SITE DEVELOPER/APPLICANT:  
Engineering comments on Page 5.

<b>SITE NAME:</b>	COLORADO SPRINGS, CO - 100KM	<b>SITE ADDRESS:</b>	7113 SPACE VILLAGE AVE COLORADO SPRINGS, CO 80929 (EL PASO COUNTY)
<b>PROJECT DESCRIPTION:</b>	NEW LEASE AREA	<b>APN:</b>	5417001012
		<b>JURISDICTION:</b>	EL PASO COUNTY
		<b>ZONE:</b>	INDUSTRIAL (I-3)

THE SCOPE OF WORK INCLUDES INSTALLATION OF A PROPOSED 98'-5"x196'-10" FENCED GRAVEL COMPOUND WITH SMALL SATELLITE EARTH STATION ANTENNAS (40 ANTENNAS AND 1 HEAD END EQUIPMENT RACK) IN EXISTING GRASS AREA. POWER TO BE PROVIDED FROM EXISTING UTILITY POLE COMING FROM SPACE VILLAGE AVE. FIBER TO BE PROVIDED FROM NEW FIBER DEMARK WITHIN RIGHT OF WAY.

PROPOSED SITE PLAN
SCALE: 1" = 60'

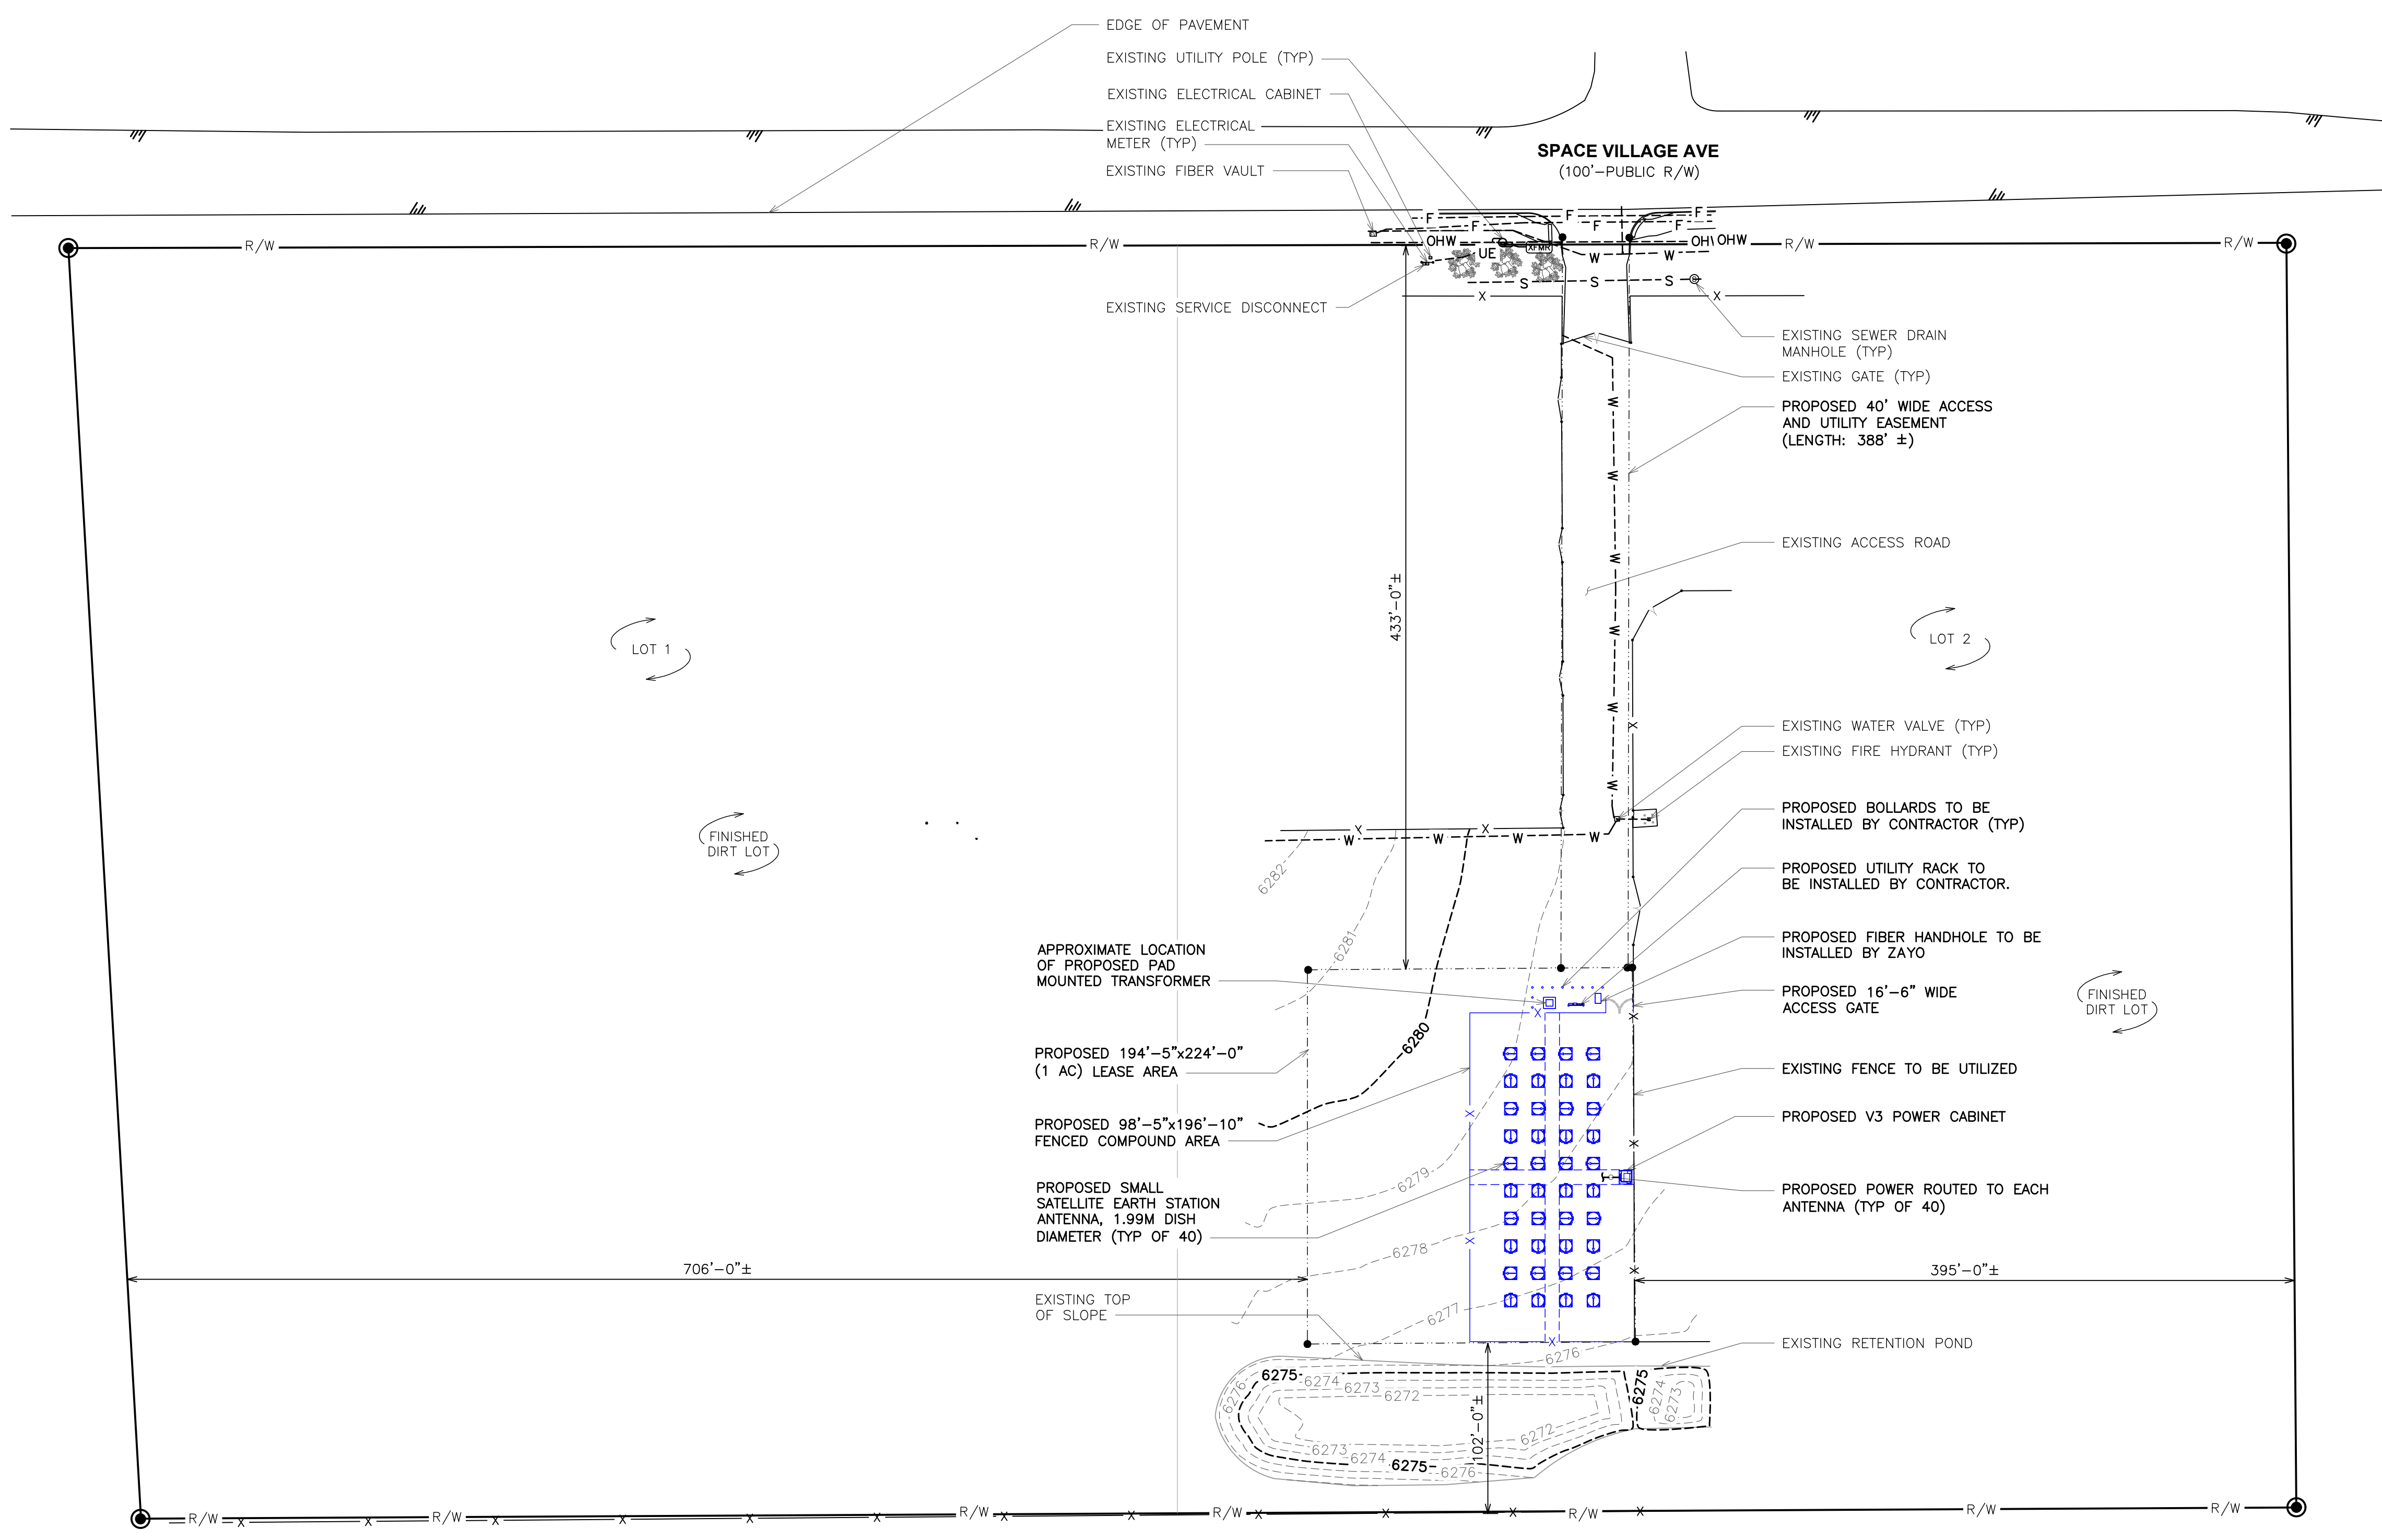
The red box drawn on the aerial image represents the only approved land use in the image. The unapproved land use(s) will need to be resolved prior to the approval of this application. A traffic memo may be required as a part of that application and Road Impact Fees will apply.

Please submit a revised Site Development Plan showing all existing and proposed activity on the site. The approved Site Development Plan we have on file (PPR233 shown below) does not depict the developments as shown in the imagery above. Or submit individual Site Development Plans per use. Please reach out to Planning and Community Development staff to submit the requested plans.
